**Your Ref: 2021/94280**  
**Our Ref: Y014662**

**5th January 2023**

**land at, Lady Ann Road, Soothill, Batley, WF17 0PY - Erection of 65 dwellings with associated works**

1. Precedent planting
2. Native hedgerow
3. Wild flower meadow
4. Path with planting
5. & 6. Community orchard
7. Wild grasses
8. & 9. Street trees and front gardens

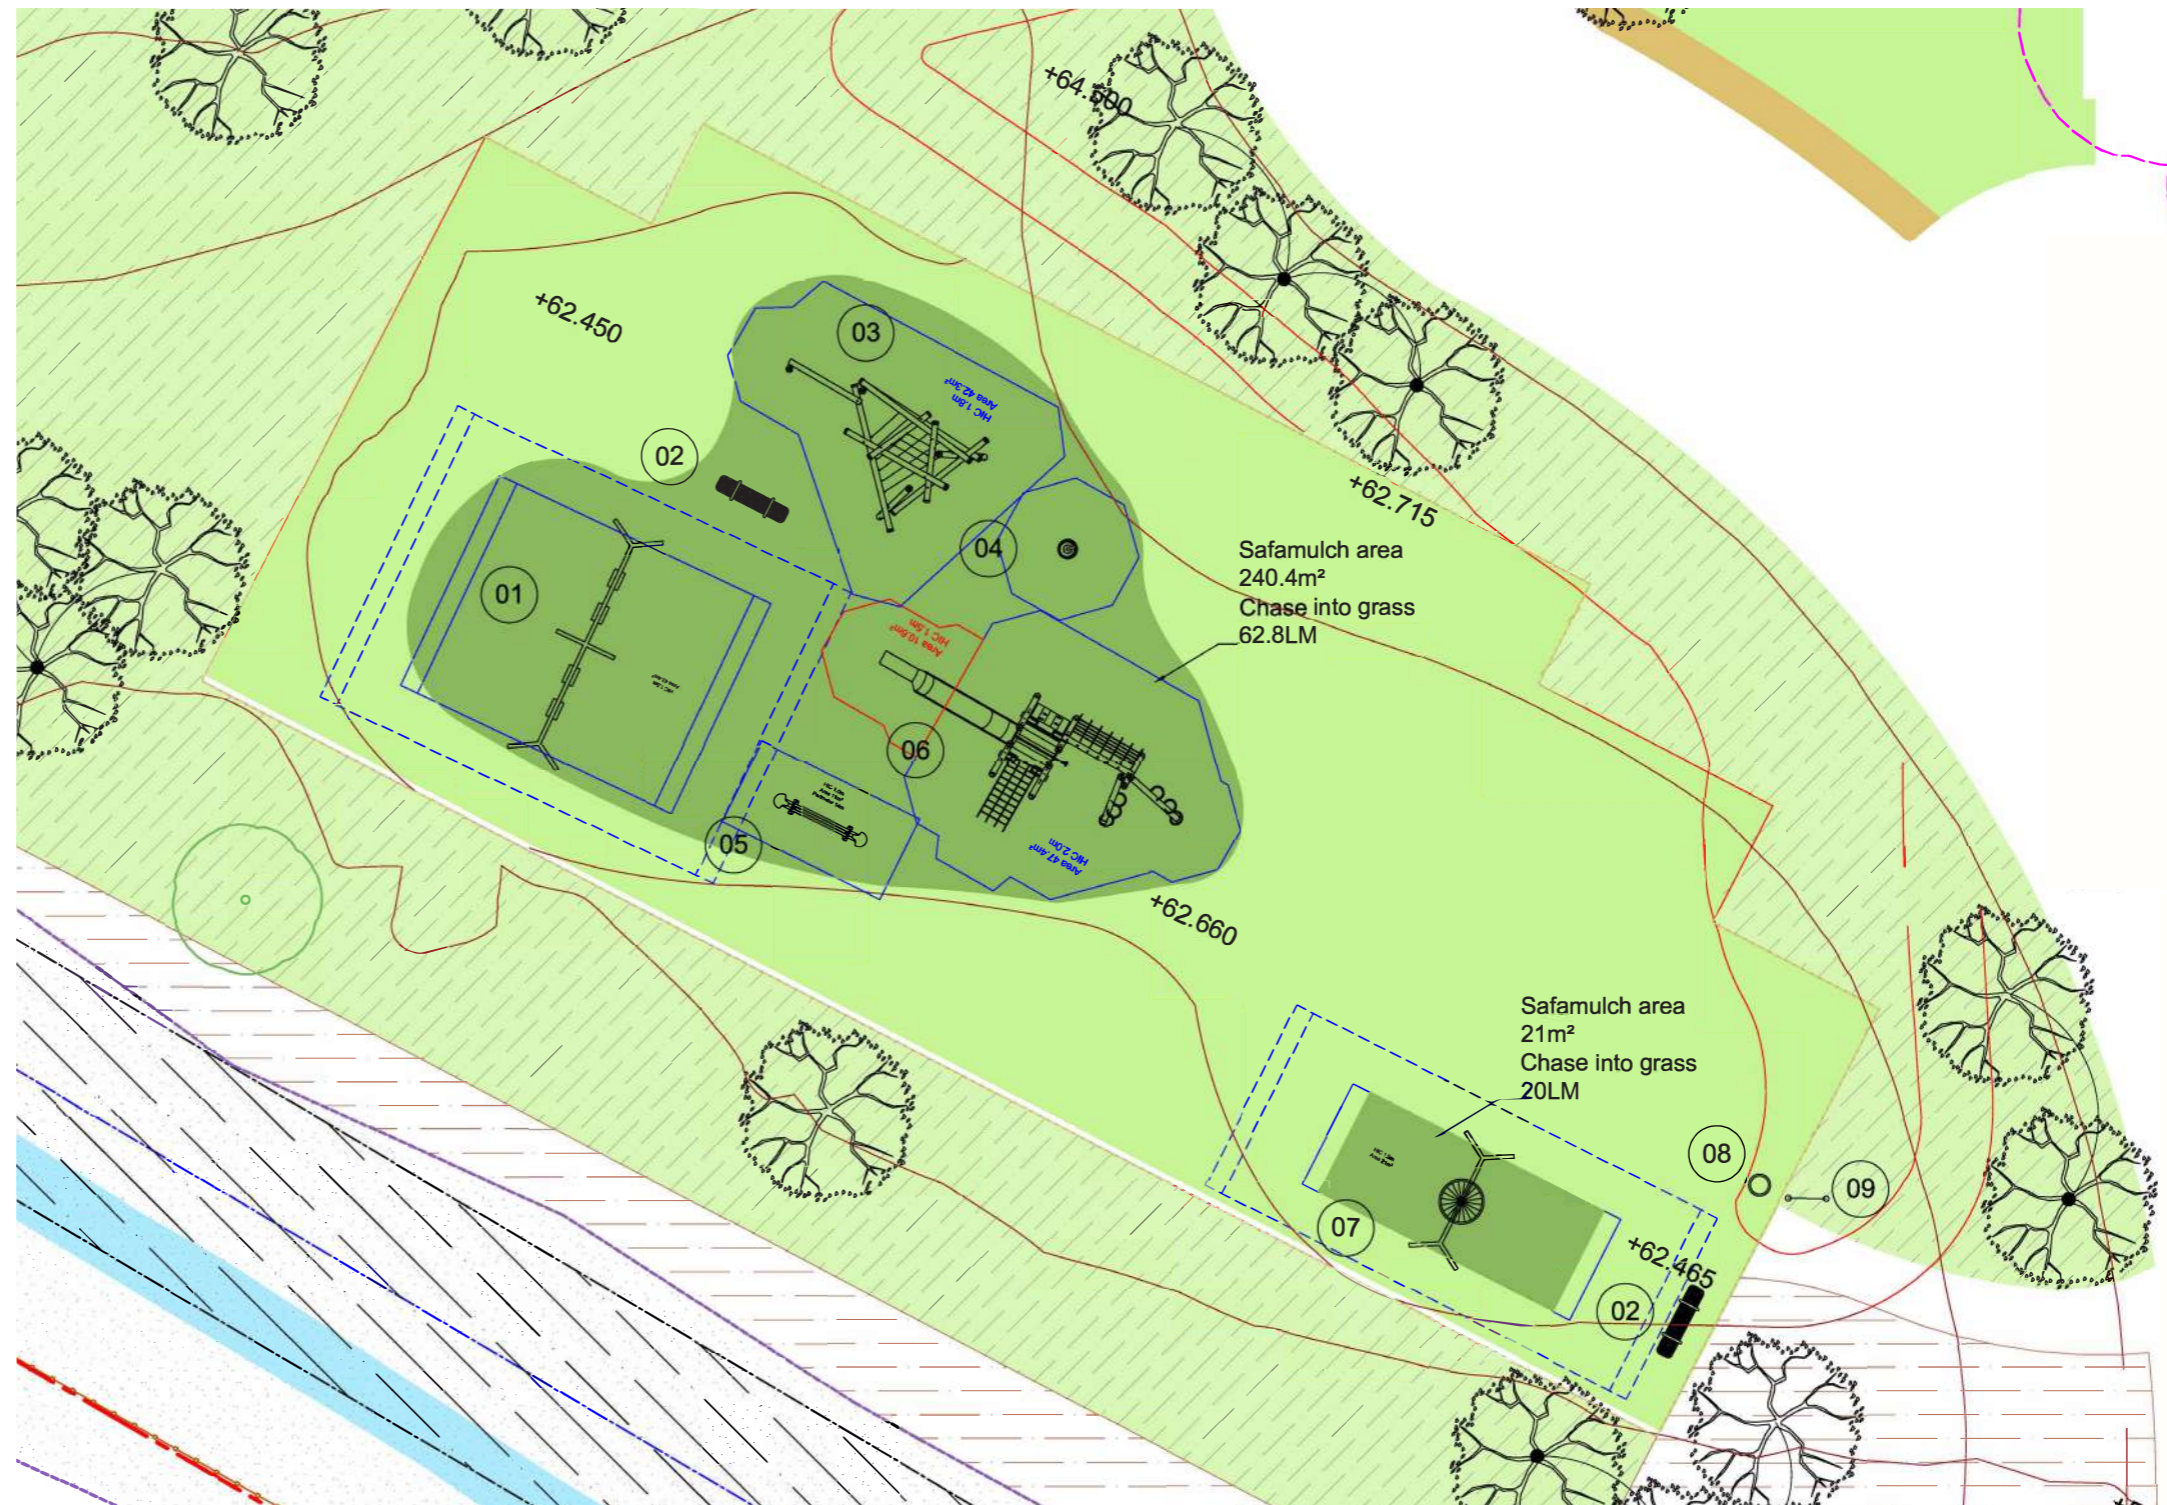
1.) The layout / landscaping details submitted on drawing 'Landscape Proposals' 0138 GA-004 (rev PL01) dated that has been prepared by Topia requires amendments, but if planning permission is granted, the matter can be dealt with via condition. The following point(s) should be addressed:

a) the submitted drawing appears to show new tree planting within 5 metres of the public sewer network.

d.) There should be no new tree planting within 5 metres of the public sewer network.
